Cockle Bay Park – Response to Agency Submissions

7.3 Visibility – after 15 minutes

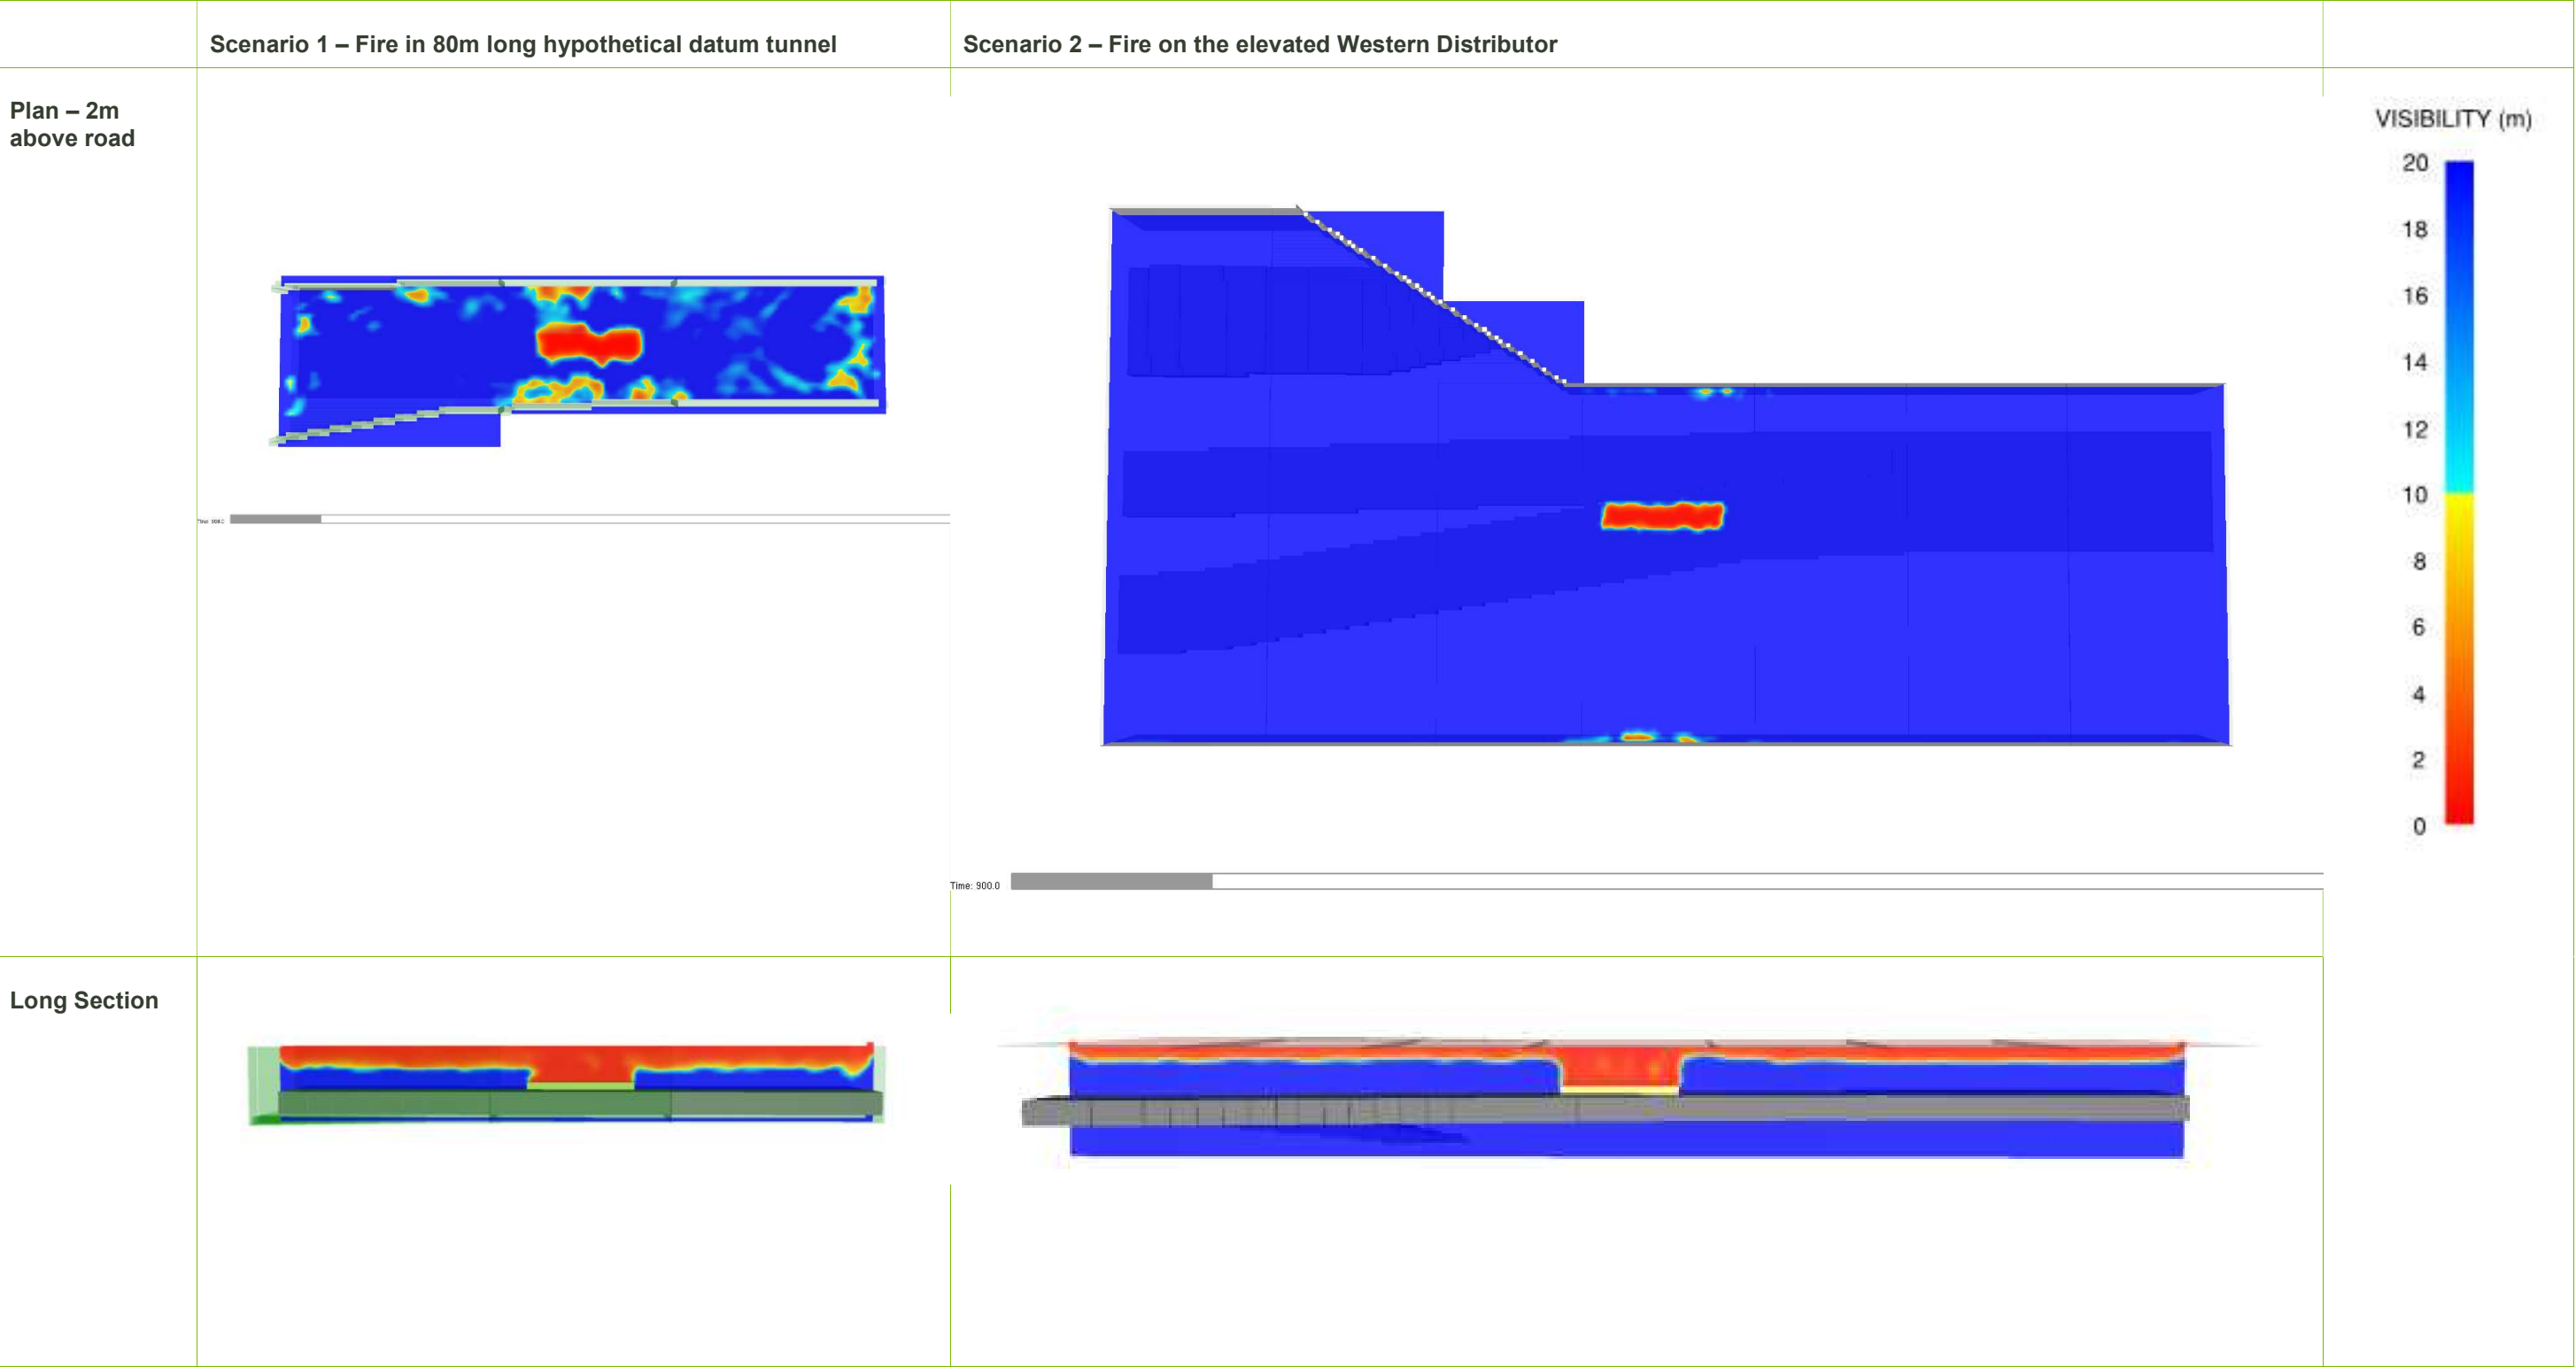
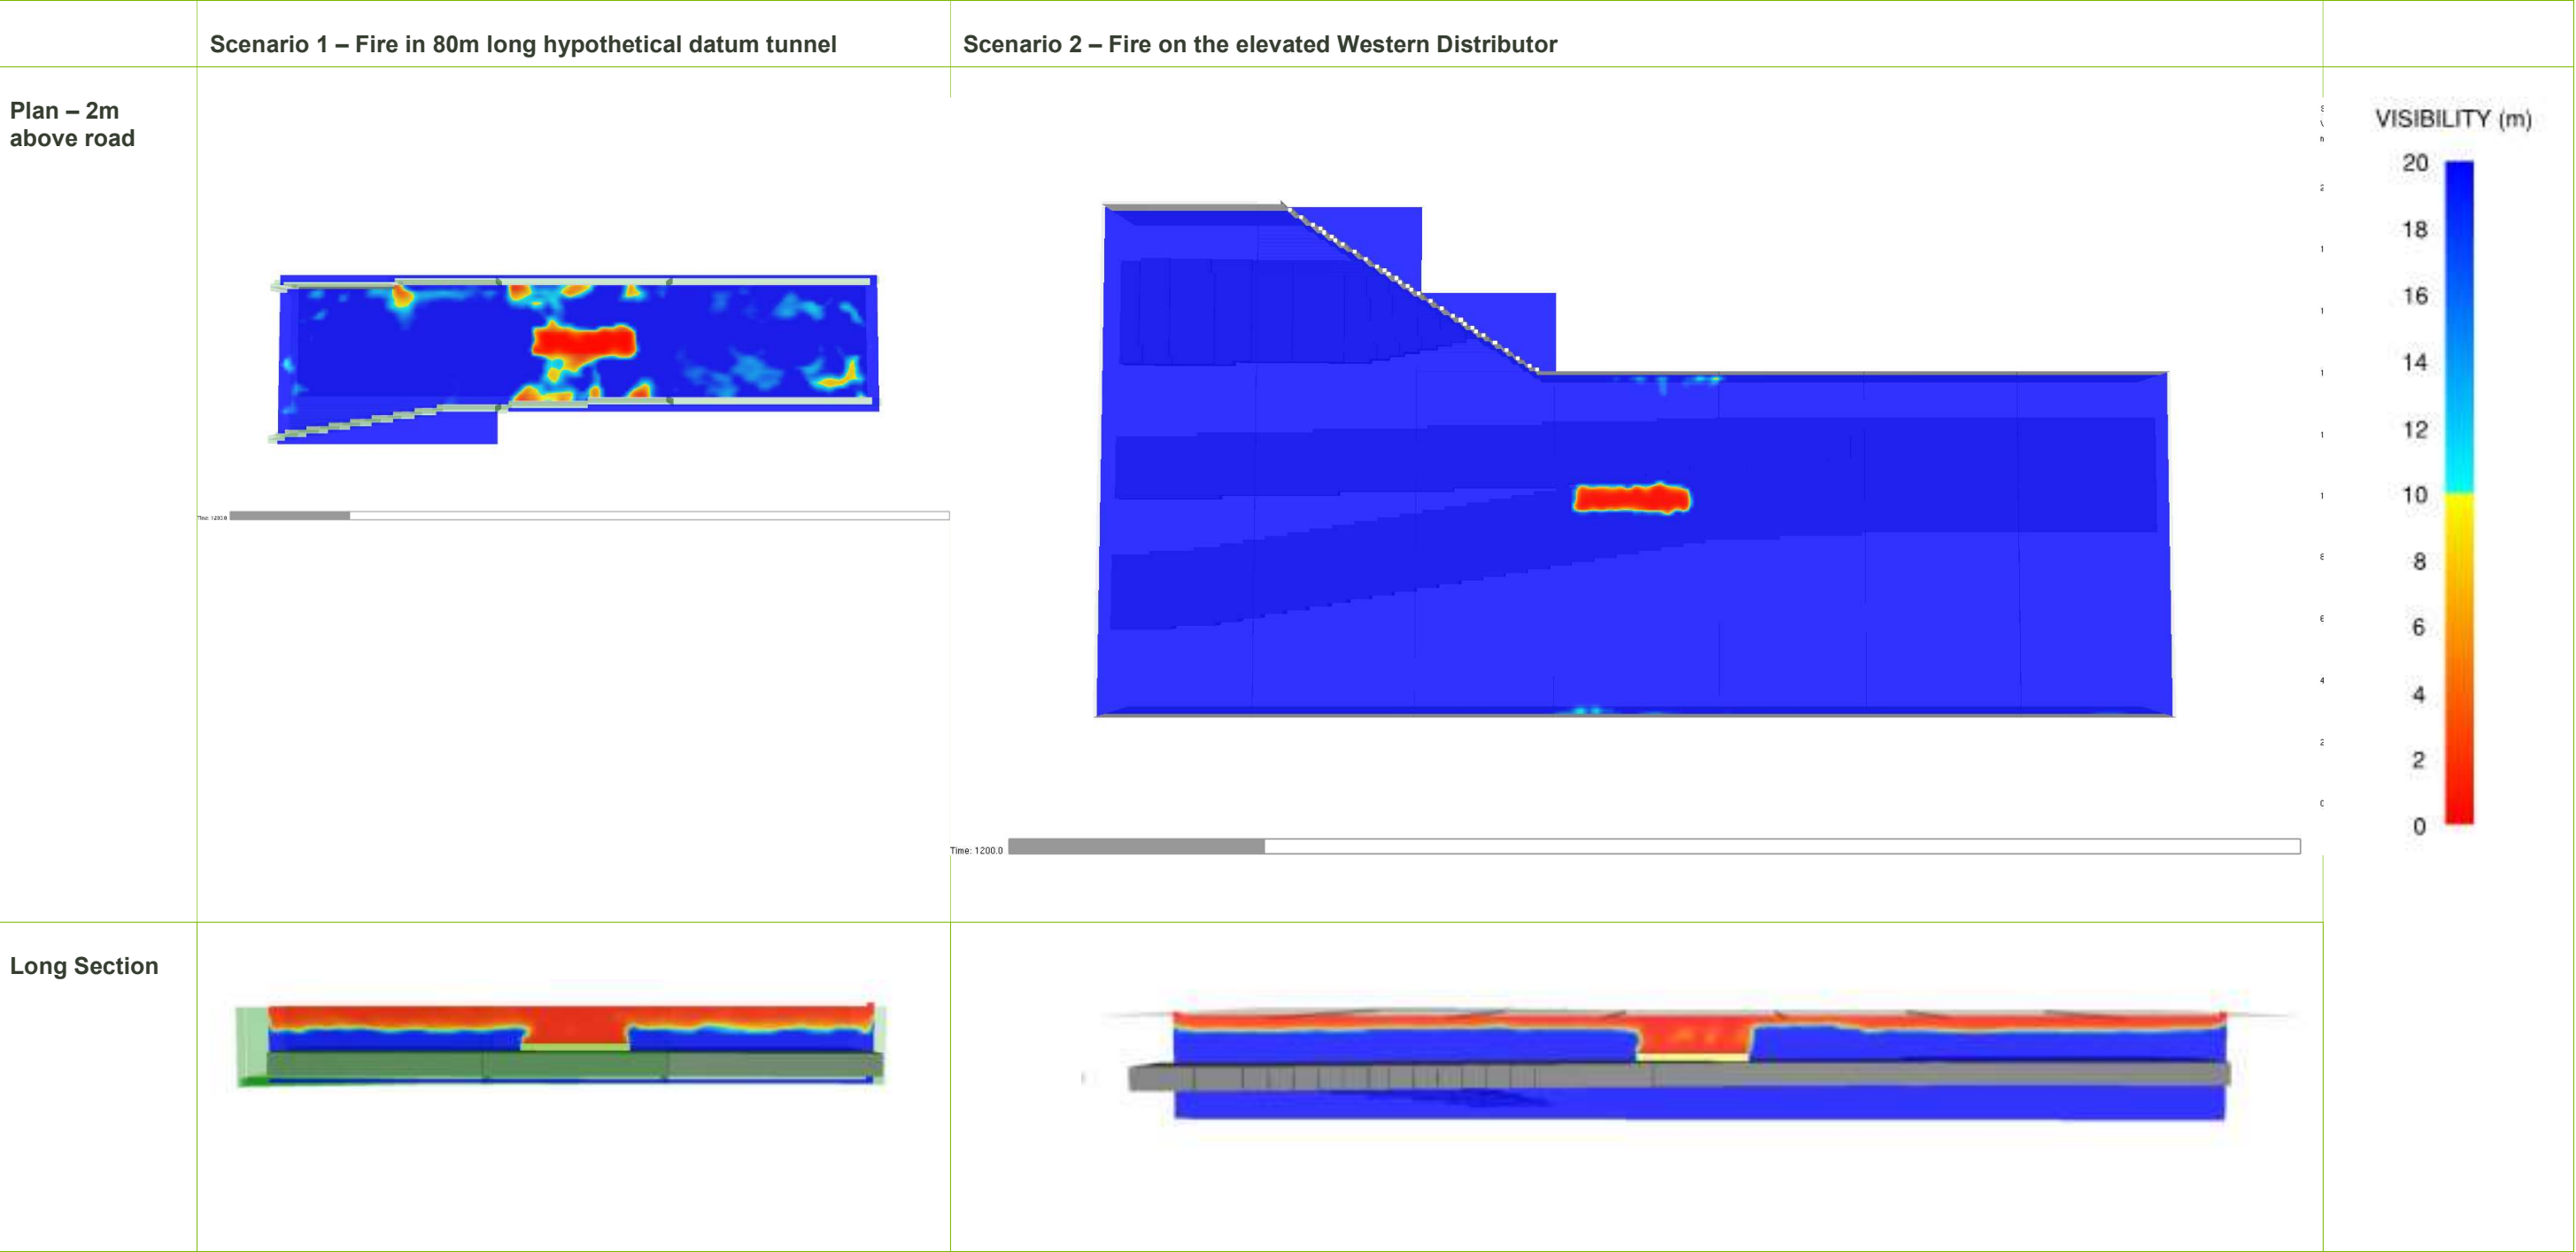
<p>Fire safety – the proposal has the effect of creating a tunnel underneath the podium – adequate provision of fire safety must be provided regarding traffic flow</p>	<p>Fire safety design criteria regarding the Western Distributor as it travels under the landbridge have been developed by Aurecon, in consultation with RMS (refer to Appendix J1). The design criteria are to be implemented at the relevant future stages of detailed design to ensure adequate fire safety provision is achieved.</p>
<p>Piering Options – RMS has request no piers in addition to the proposed piers option</p>	<p>Enstruct and Aurecon have considered structural options for landbridge pier locations including piers between on-grade northbound Harbour St and the elevated Western Distributor and an alternate 'no piers' option. The options are presented at Appendix K and Appendix W (refer to Section 7.20 of the</p>
